From: Emma Avis [REDACTED]
Sent: 11 June 2019 10:24
To: Simon Davis <Simon.Davis@arun.gov.uk>
Subject: RE: BE/58/19/RES The Cottage, Shripney Road Phase 1

From: Simon Davis <Simon.Davis@arun.gov.uk>
Date: May 23, 2019 at 10:55:14 AM GMT+1
To: Chris Barker [REDACTED]
Subject: BE/58/19/RES The Cottage, Shripney Road Phase 1

Drawing No
004

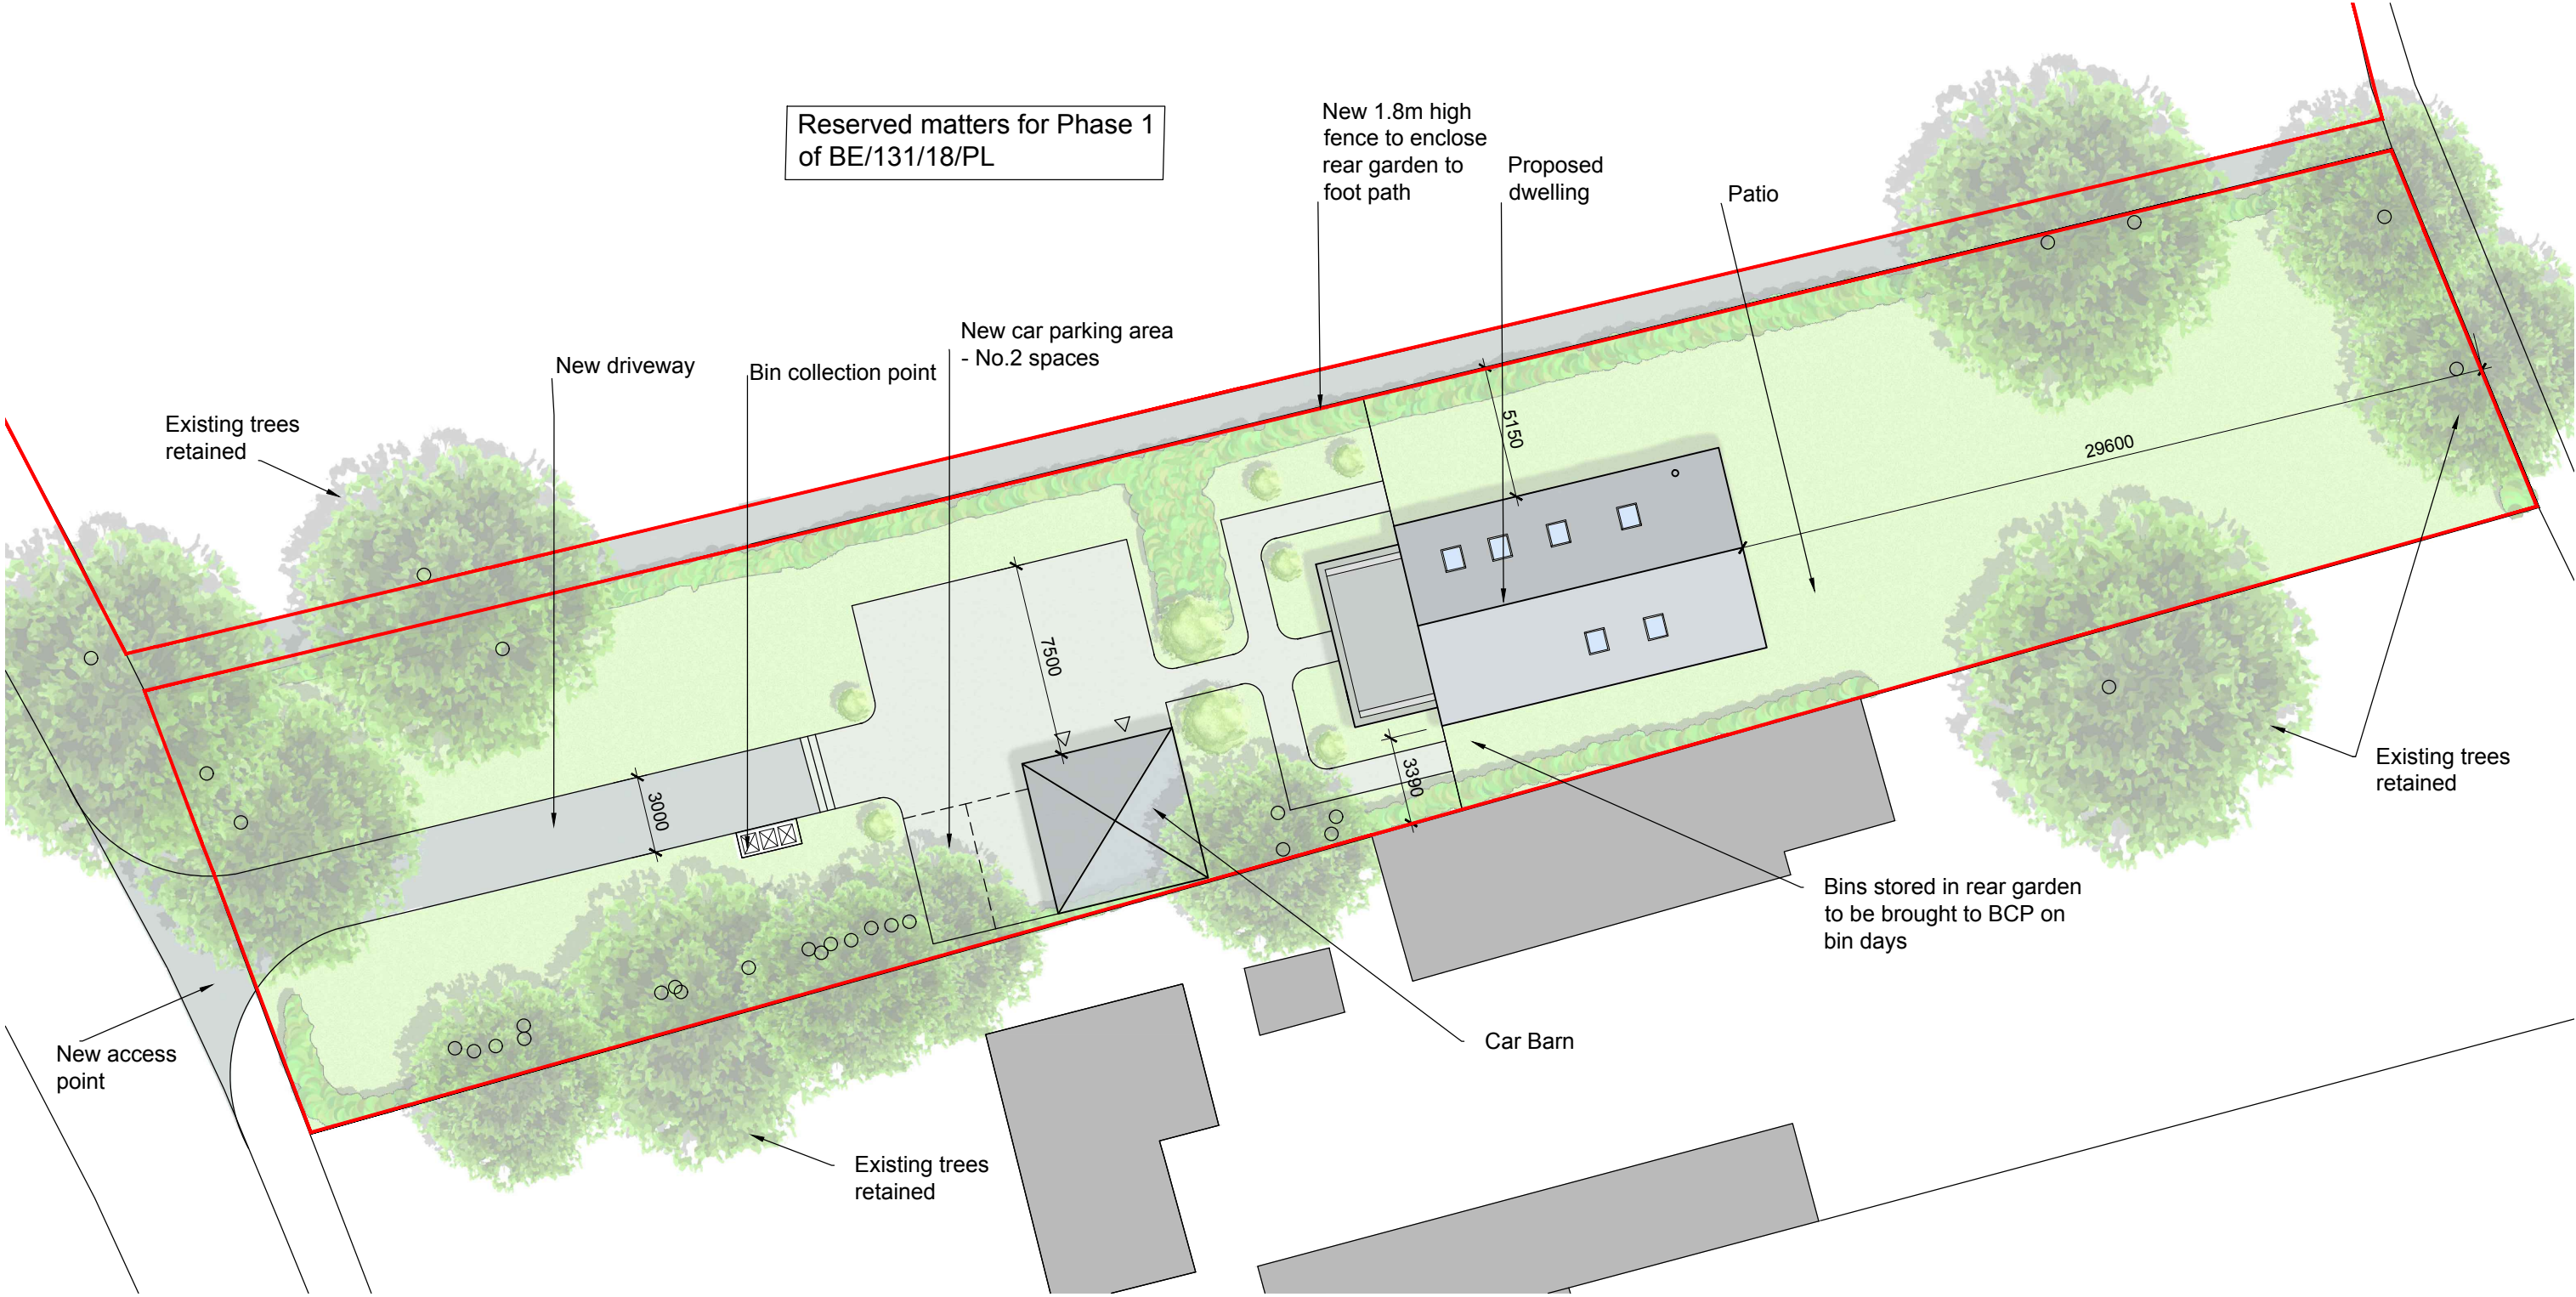
Please note that the applicant have amended the site plan to remove the reference to "new access". This is in response to your consultation advice from 21/05/19

Yes I think it would be helpful and avoid any confusion down the line if you could amend the plan to change the annotation.

I'd be grateful for your confirmation regarding the access as per the query in the attached Highways comments.

With reference to our correspondence yesterday, please find attached a revised site plan which no longer refers to a new access.

Sorry, this was an error. It is proposed to upgrade the existing cross over point in accordance with the approved outline application rather than provide a new access point.
